**WELWYN HATFIELD COUNCIL – DEVELOPMENT CONTROL  
DELEGATED REPORT**

<b>APPLICATION No:</b>	<b>S6/2011/0243FP</b>
------------------------	-----------------------

**DESCRIPTION OF PROPOSAL:**

PROPOSED Adj. SIDE ELEVATION
scale 1:50

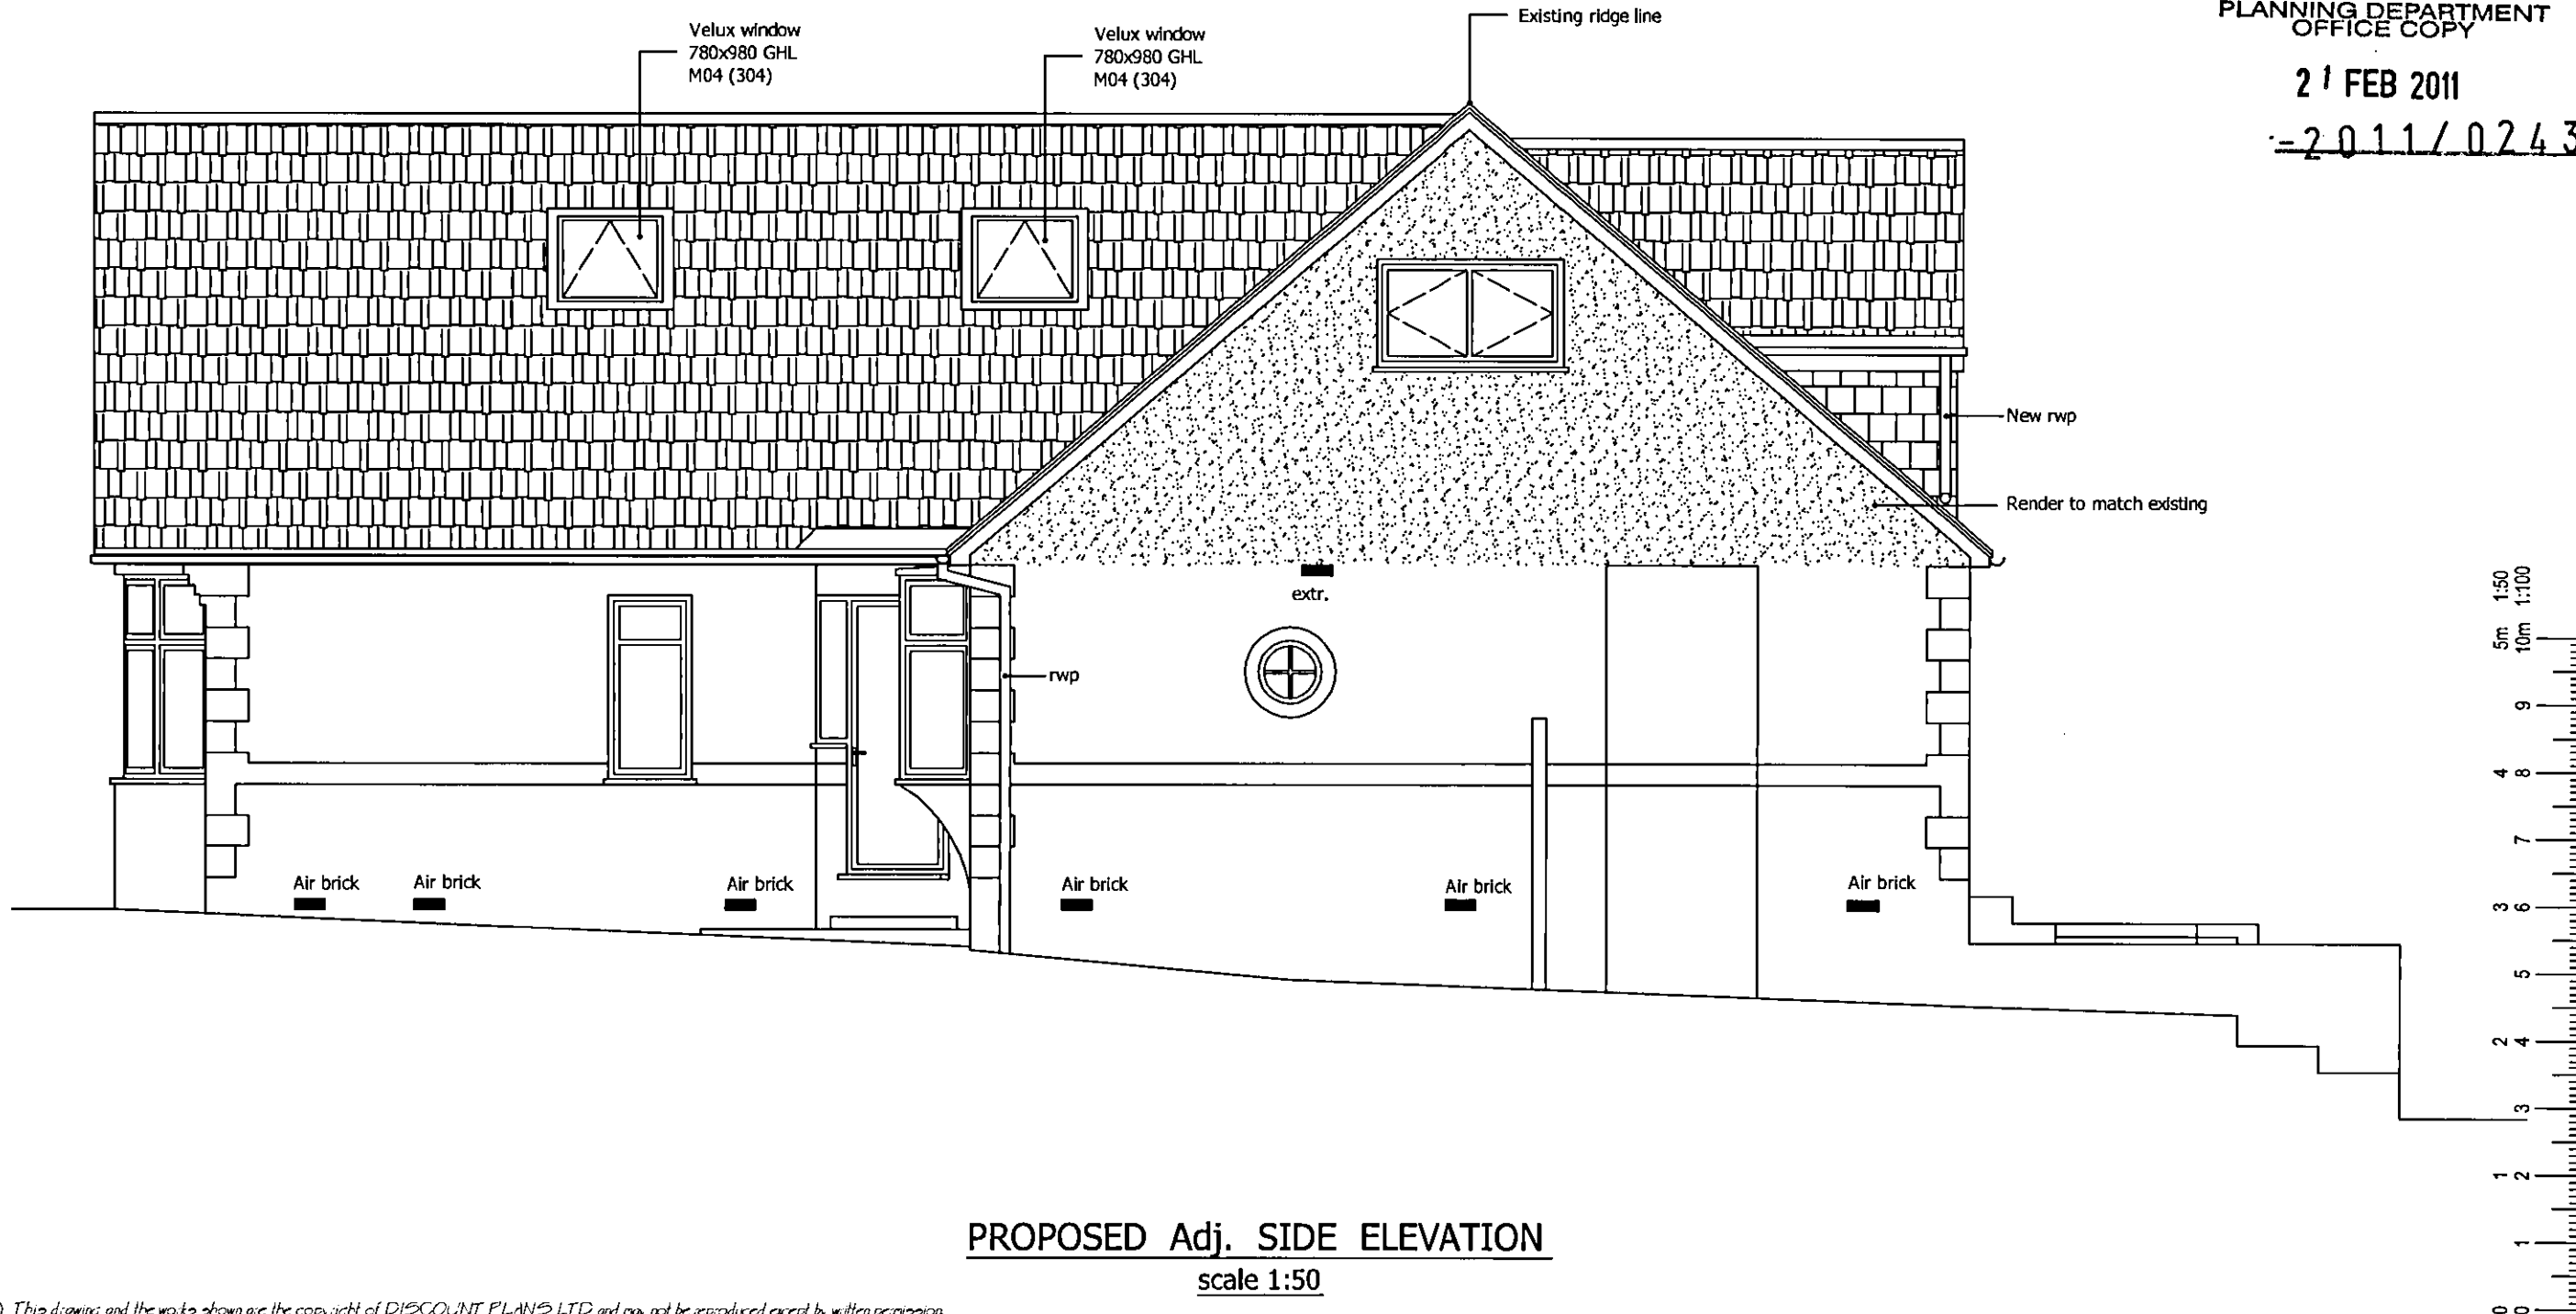
The main changes relate in this application to the first floor, where two new gable ends are proposed as part of the enlarged roof. These additions would significantly reduce the visual gap which currently exists at this level. Although a visual gap still remains from the common boundaries, the significant reduction of this gap and distant views beyond would be very noticeable from the public highway. This in turn would have an adverse impact on the open character, appearance and pattern of development in the surrounding countryside.

The proposed first floor would result in two new gable windows in the side walls. One would serve a bathroom and the other would be a secondary window to a bedroom.

Both of these windows can be subject to a planning condition for obscure glazing and so the impact on these neighbours from overlooking and privacy can be adequately controlled.

DRAWING No. **DPL.09.** | REVISION -

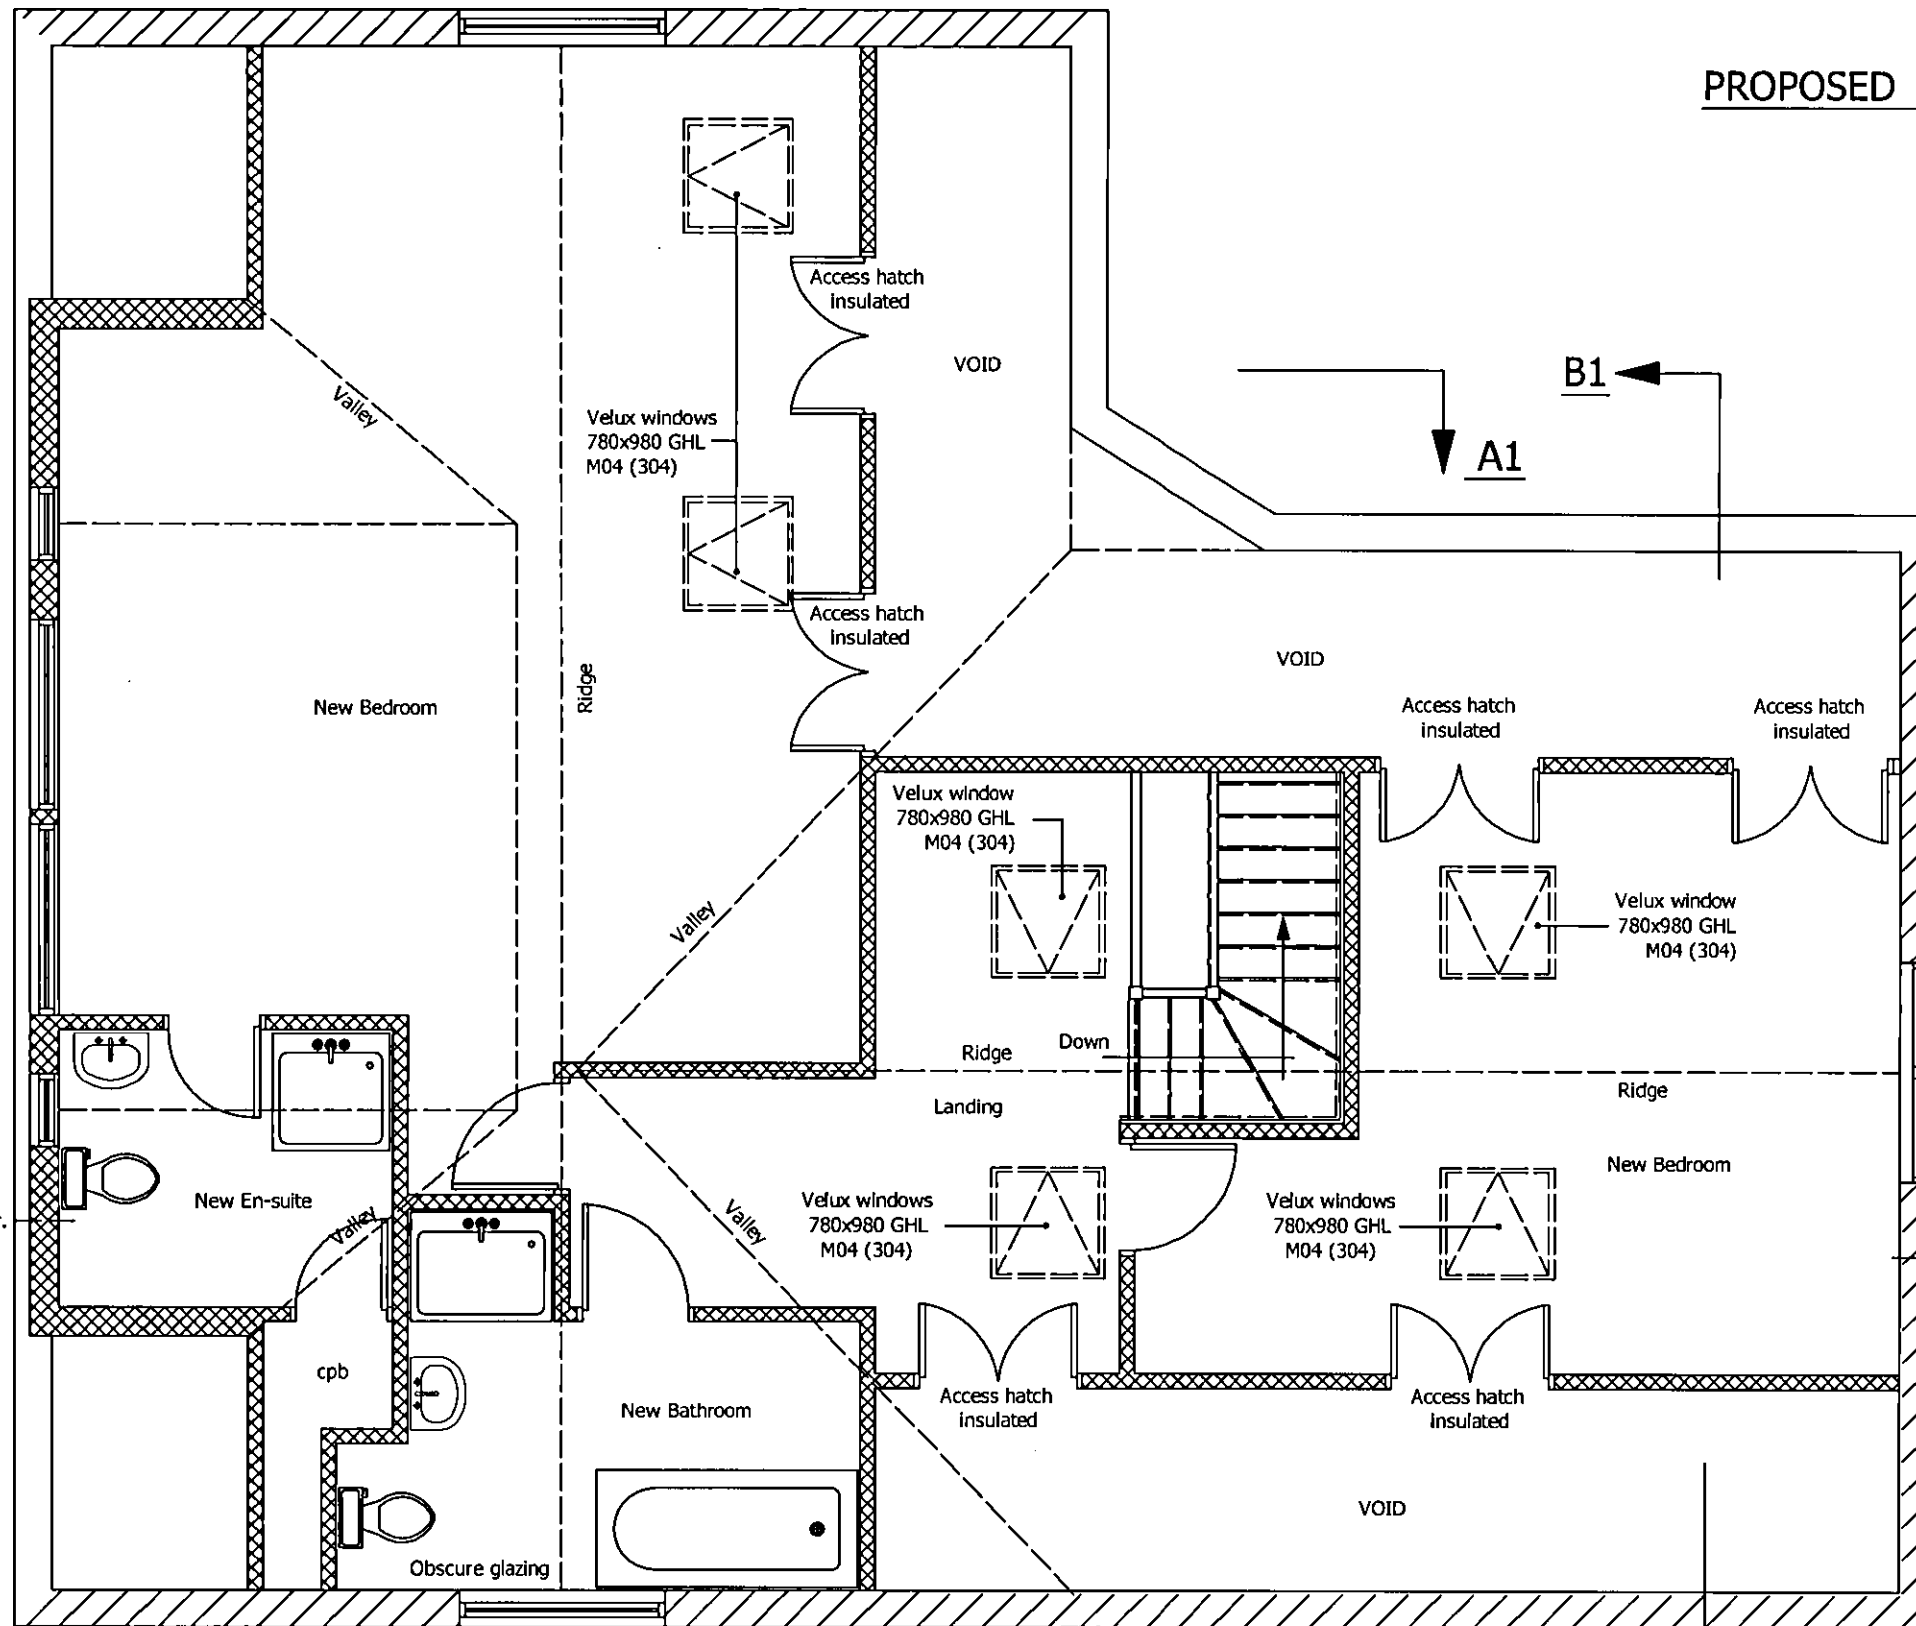
The new roof will have six rooflights and also a rear dormer with a part pitched roof and central flat roof.

A new staircase would provide access to the first floor, with 2 new bedrooms, one with an en-suite and also a separate bathroom.

It is accepted that the new floorspace would be contained mainly within the new roofspace. Whilst the height of the roof would remain unaltered, there would be a sizeable increase in the volume and floor area of the dwelling. There would also be a significant increase in the bulk and mass of the dwelling at first floor level, and this would be especially apparent to the front and rear of the dwelling. Overall the proposal would represent a substantial and 'disproportional' addition to the size of the original dwelling which would harm the openness of the Green Belt.

PROPOSED FRONT ELEVATION
scale 1:50

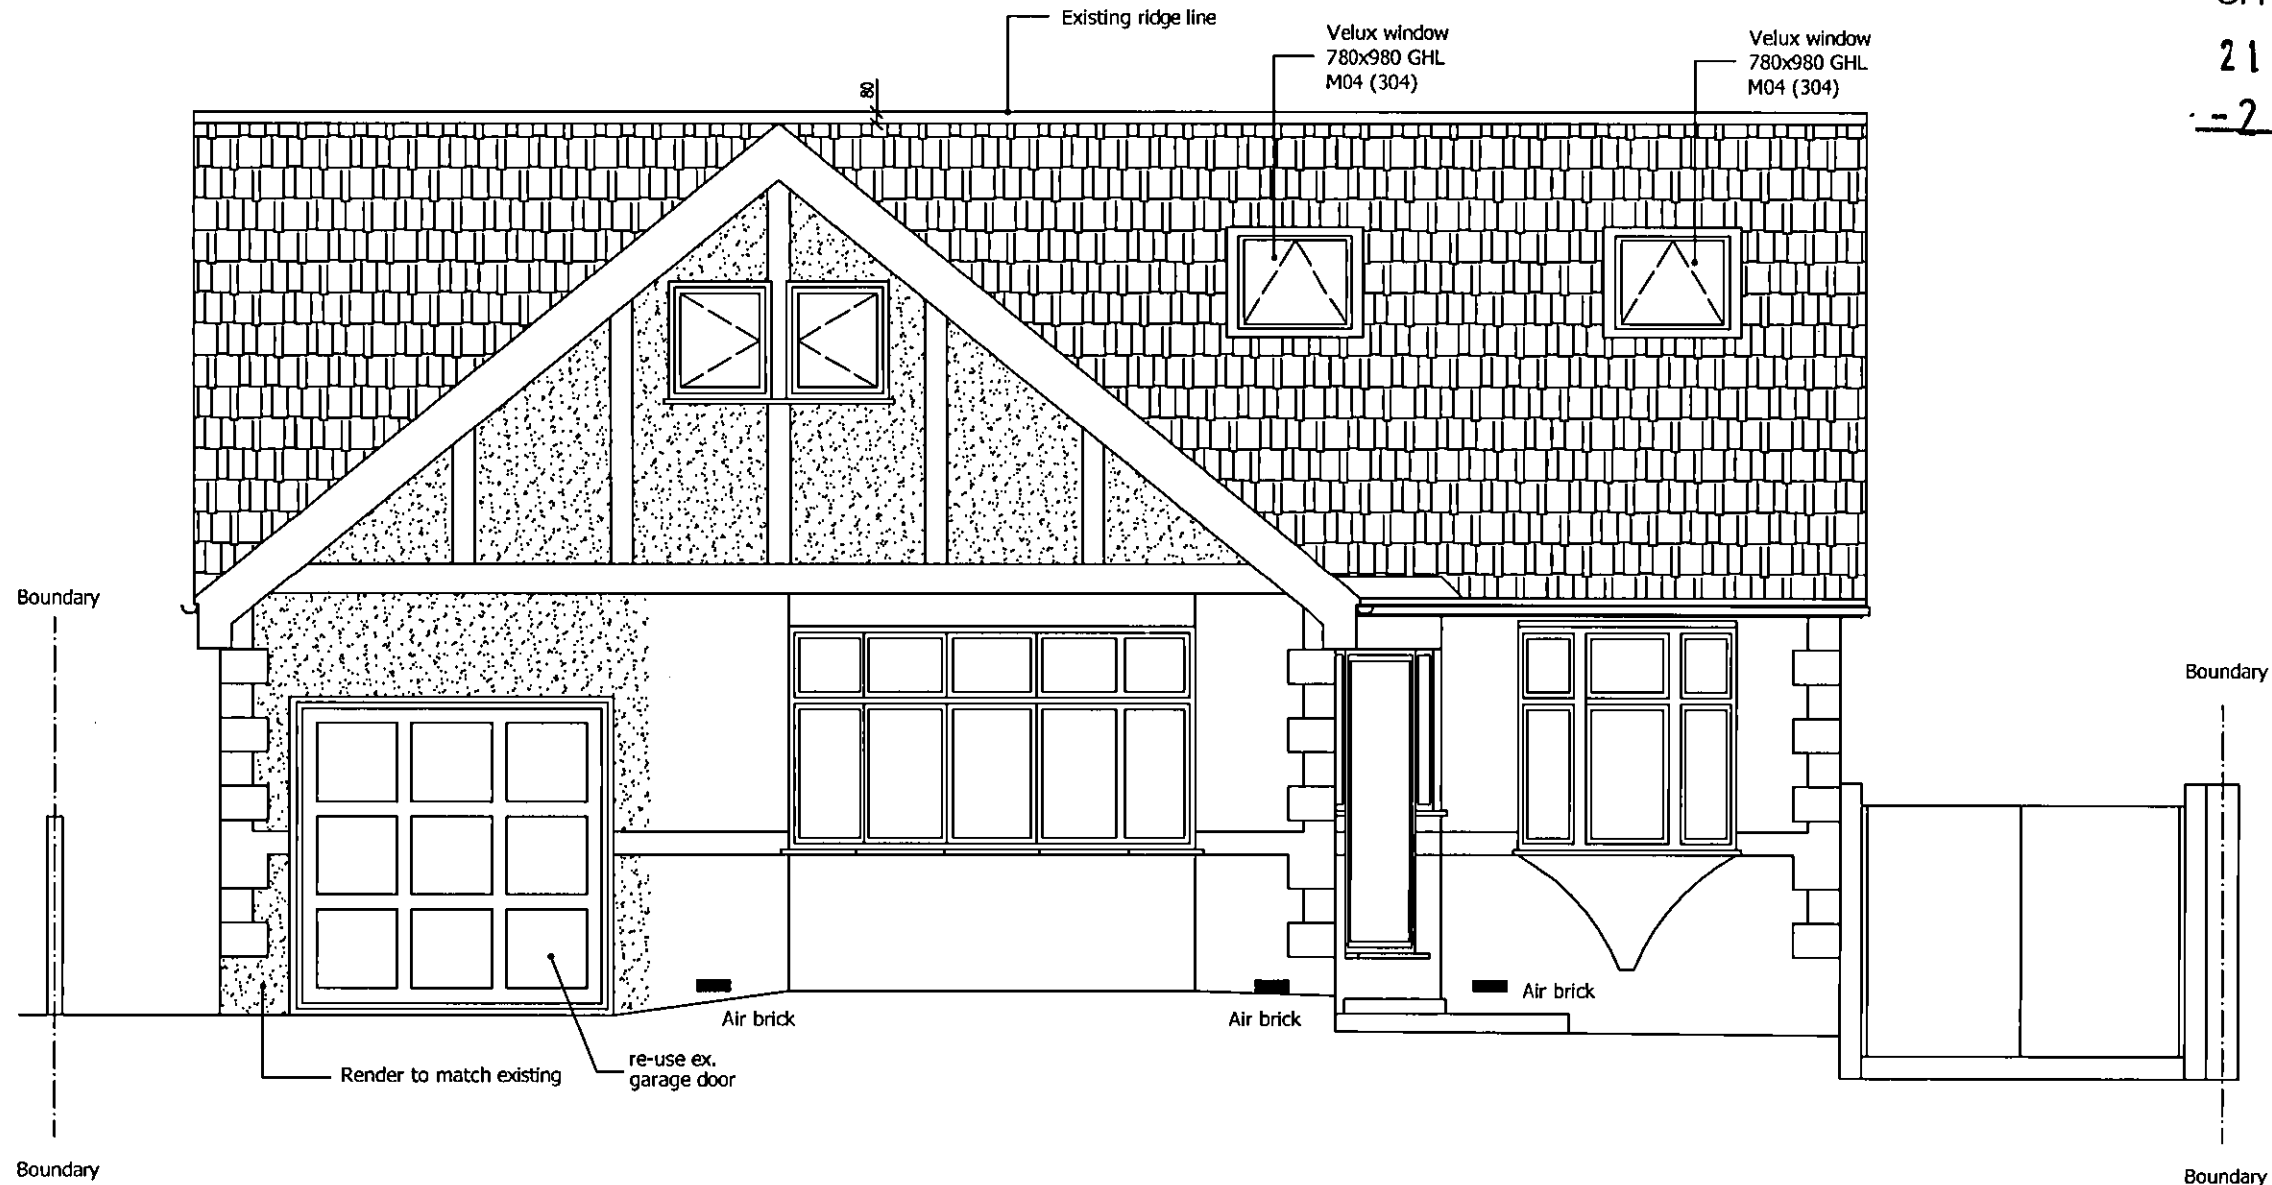
At the front, the existing gable wall would be enlarged by widening it, although the height would remain the same.

The proposed extensions, although significantly altering the existing roof, would still retain the original character of using pitched roofs and a front gable.
